**From:** planning.scanning@york.gov.uk  
**Subject:** FW: Planning Application Consultation 24/00561/FUL at 64 Beech Avenue Acomb  
**Attachments:** ufm123\_STDCN\_-\_Standard\_consultation\_letter.pdf; Waste Information for Developers 01 04 2024.pdf

The proposed waste management plan is unacceptable and rejected.

drawing:  
 Proposed Site Plan

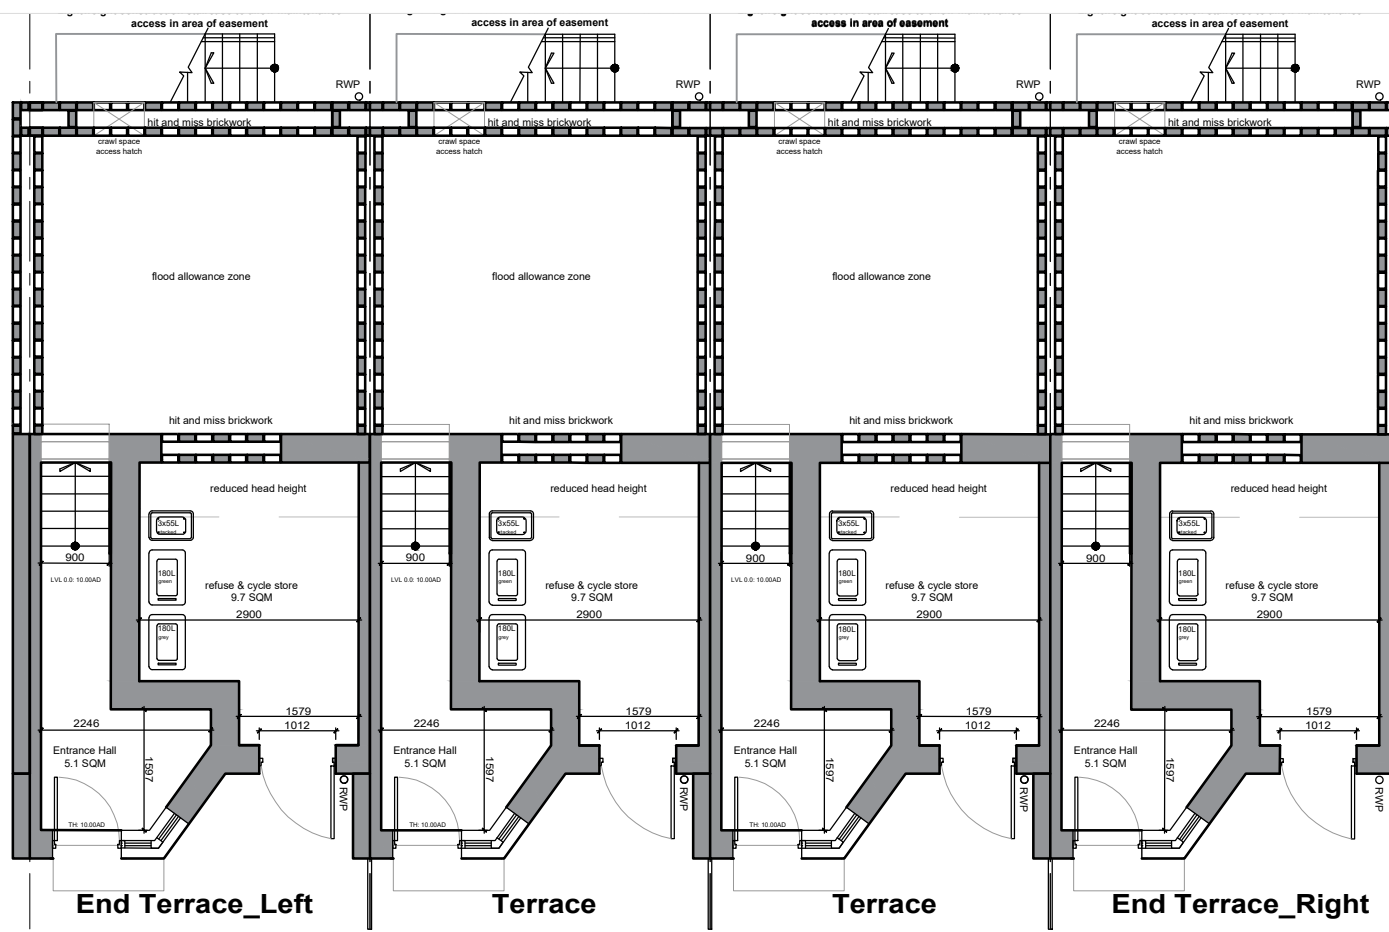
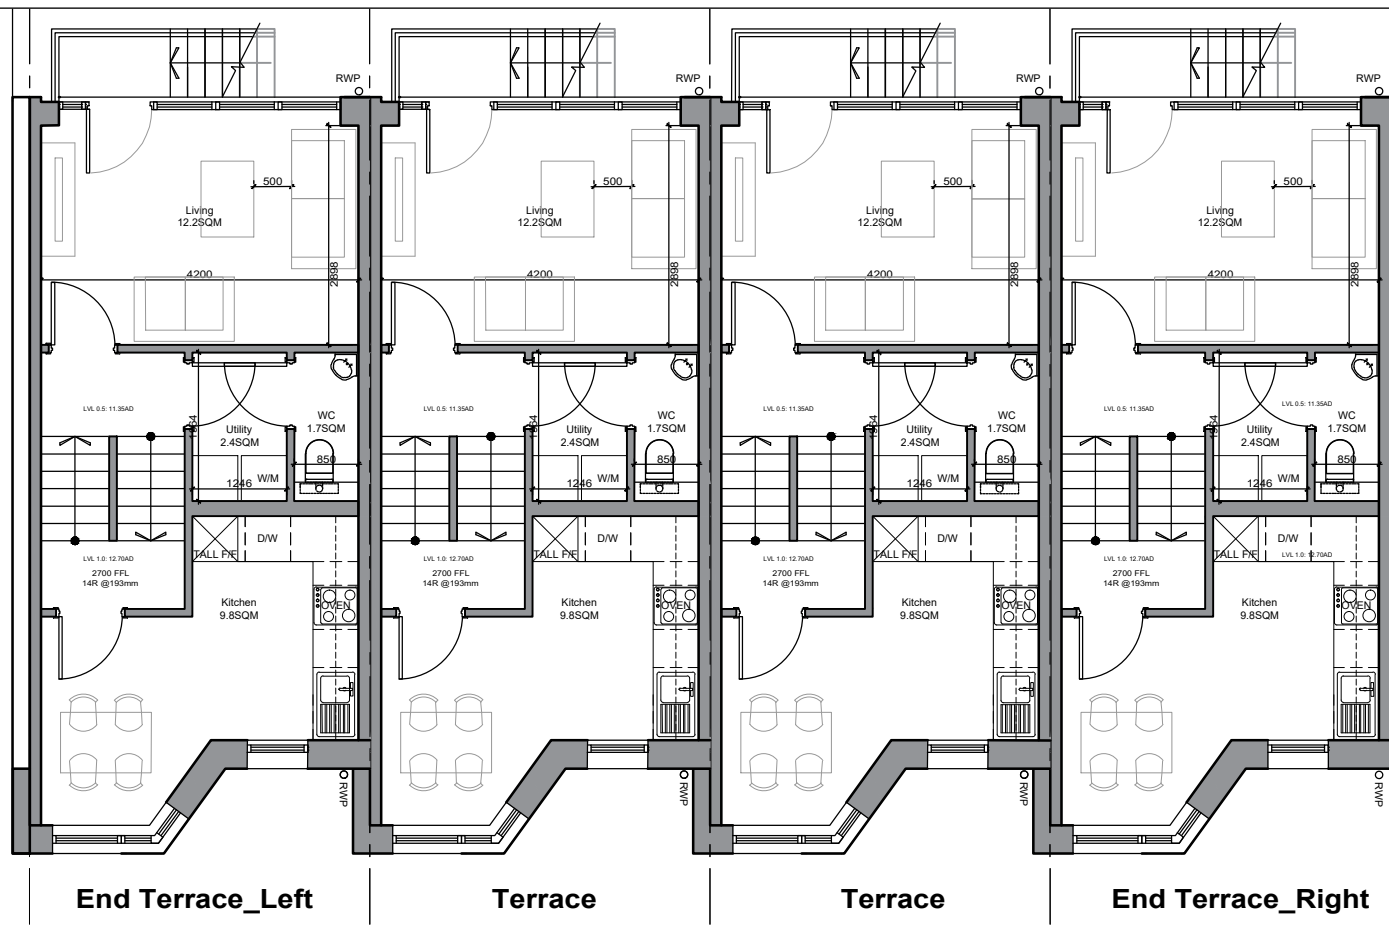
We will not collect waste via unadopted highways, as is the case with this application

The waste management plan for the proposed site should be stand-alone from any existing properties

If a bin store is to be used for the application it should be located where the access lane meets the public highway, within the boundary of the development

If individual bins are to be used for the application the bins must be presented by the residents at a central collection point located where the access lane meets the public highway, within the boundary of the development

Where a central collection point is needed, the developer is required to provide an appropriate place and hardstanding on which to place these bins for collection.
